From: Carol Reynolds
Sent: 25 May 2017 11:08
To: Planning.Responses
Subject: FW: Planning Consultation on: LU/121/17/RES

Environmental Health: I refer to the Acoustic Assessment prepared by WYG, March 2017: Reserved Matters Application (Phase 2) and Discharge of Conditions, North Littlehampton. The report provides insufficient detail for agreement to discharge of conditions 37 & 38. Specifically, Para 6 Mitigation.

APPLICATION LU/121/17/RES

Site Address: Land North of Toddington Lane Parcel C1 & part Parcels B2,
B4 & C2 Littlehampton BN17 7PP

Drawing Title:	
Site Layout - INFORMATION	
Drawing Status:	Drawn:
SUBMITTED	KJ
	Rev:
	-

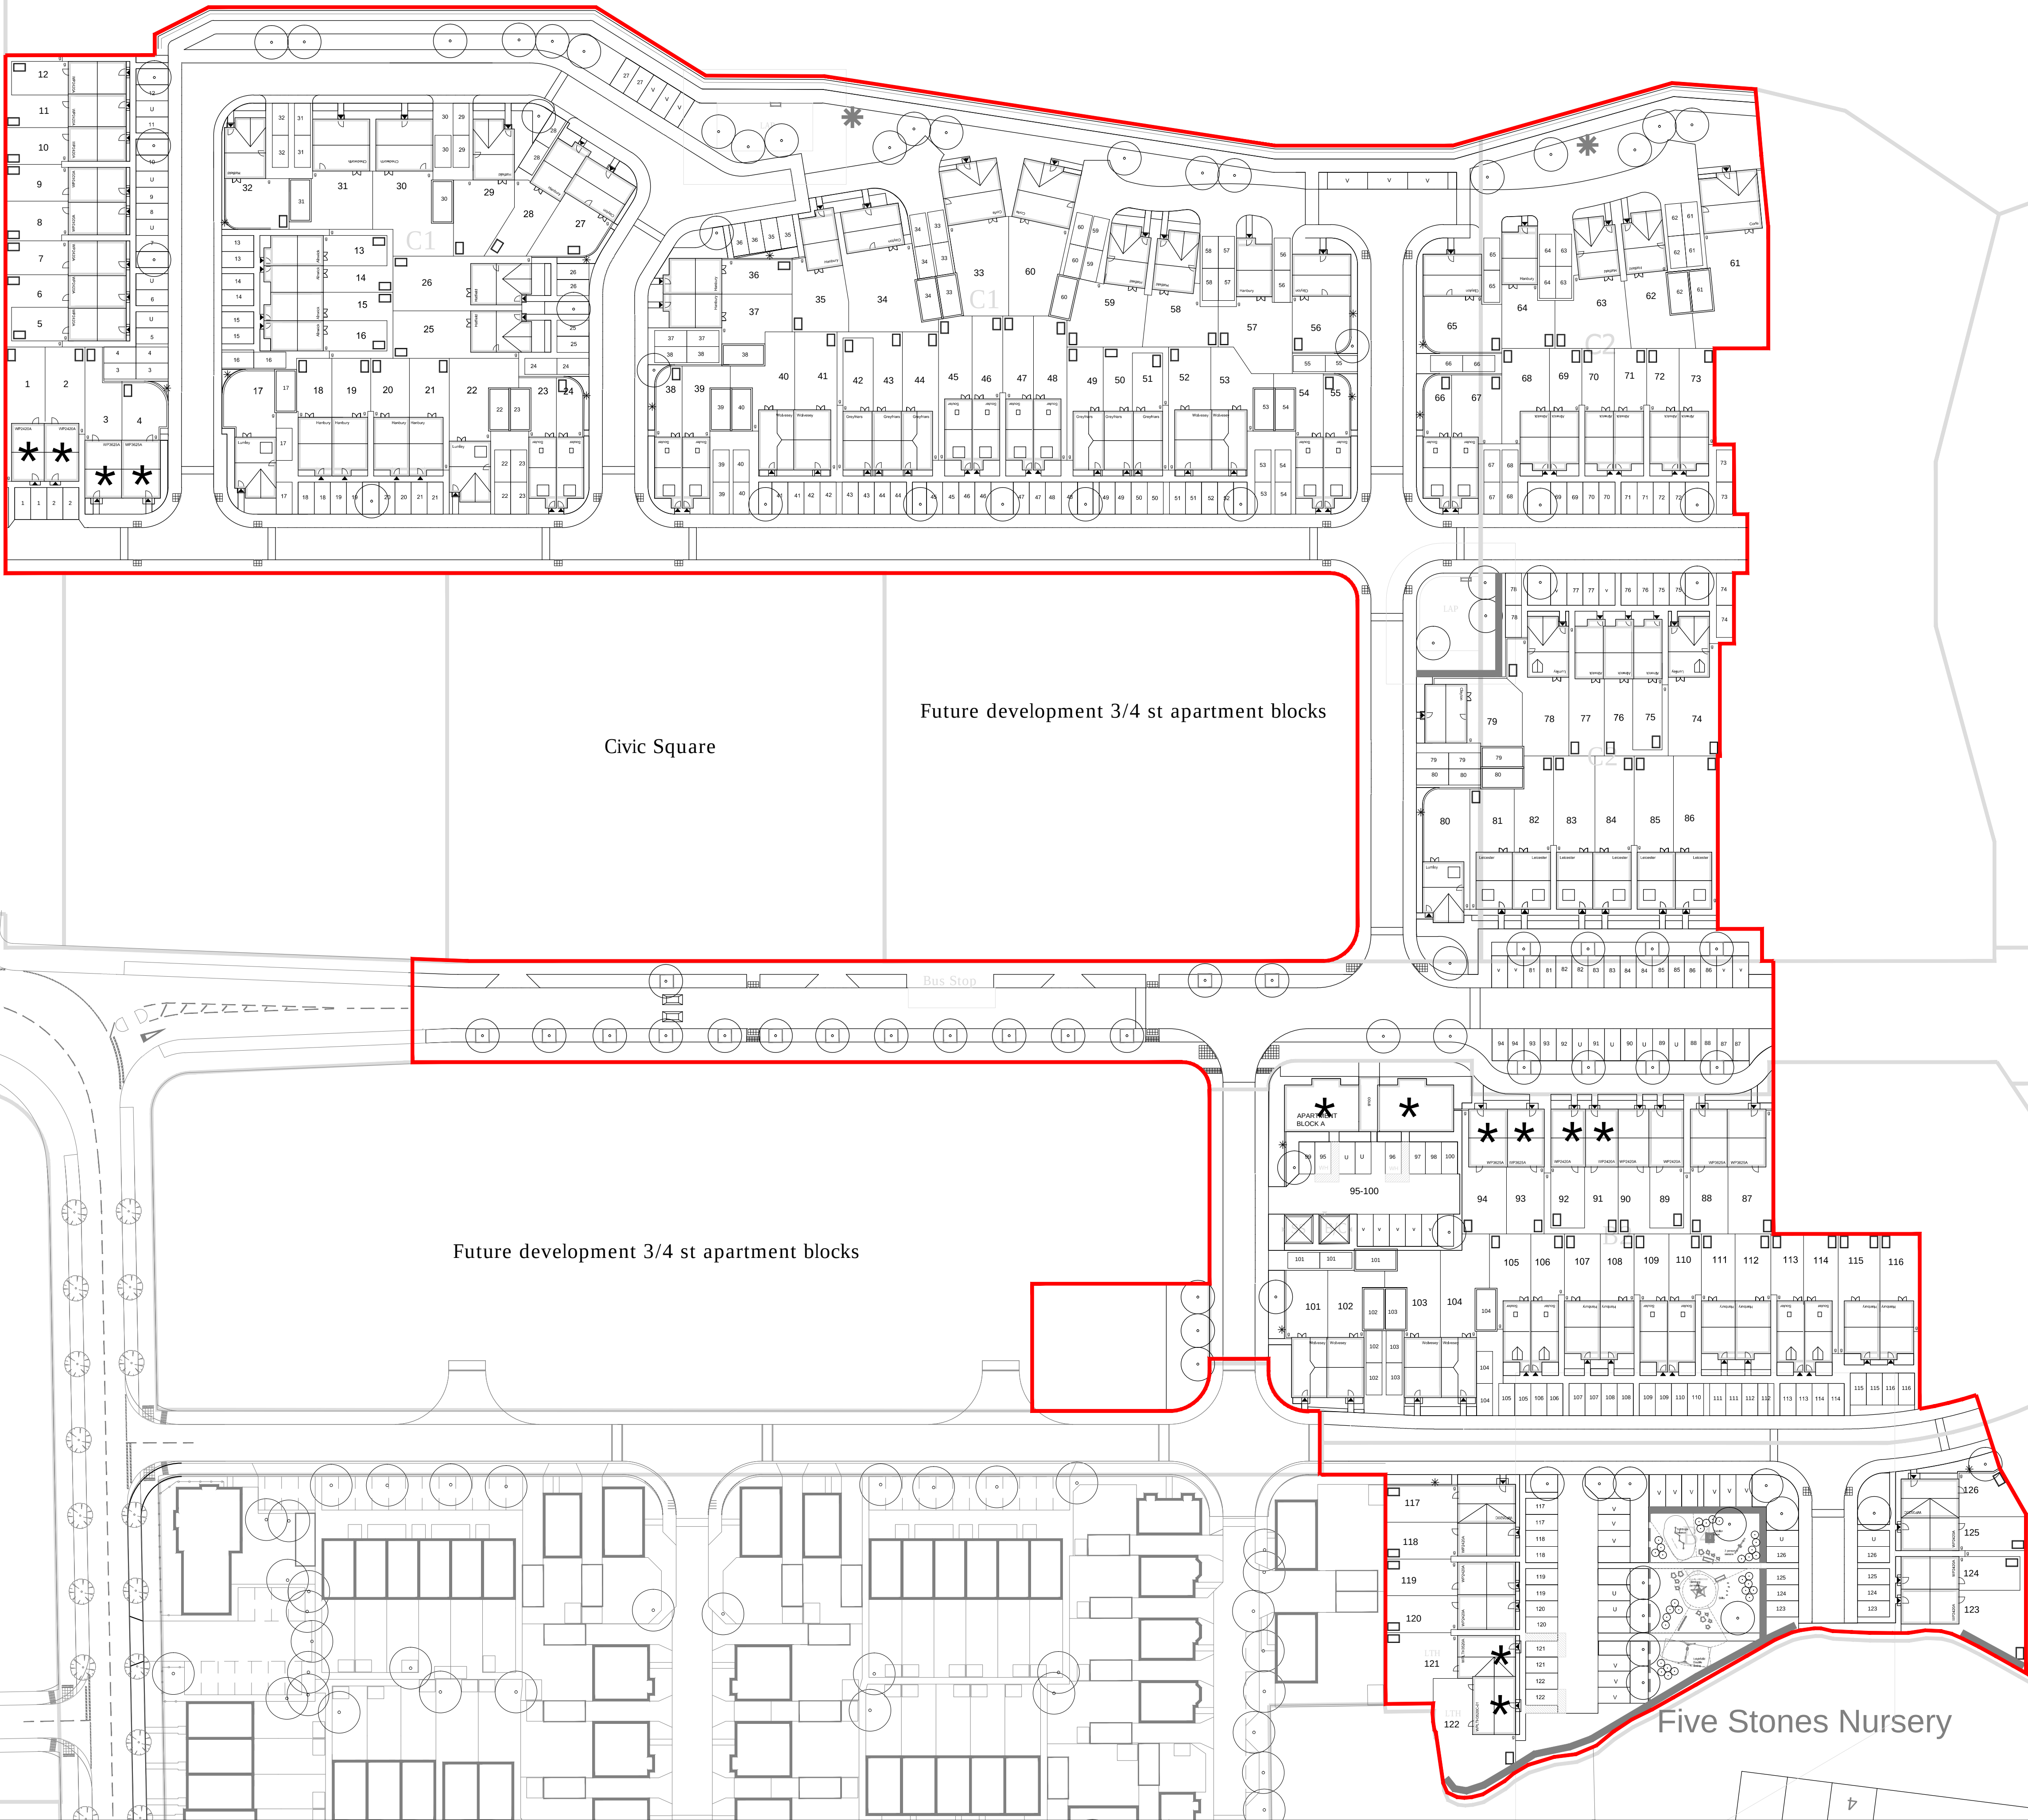
*'Building Design and Layout' Please provide the agreed layout of buildings and position of noise sensitive rooms within these in relation to the main sources of noise ie roads, in order to demonstrate the way in which building orientation and internal arrangement have been designed to reduce external noise impact.

*Fencing. Please provide detail of where acoustic fences will be positioned in order to achieve the desired mitigation. Please also provide detail of proposed acoustic fencing specification.
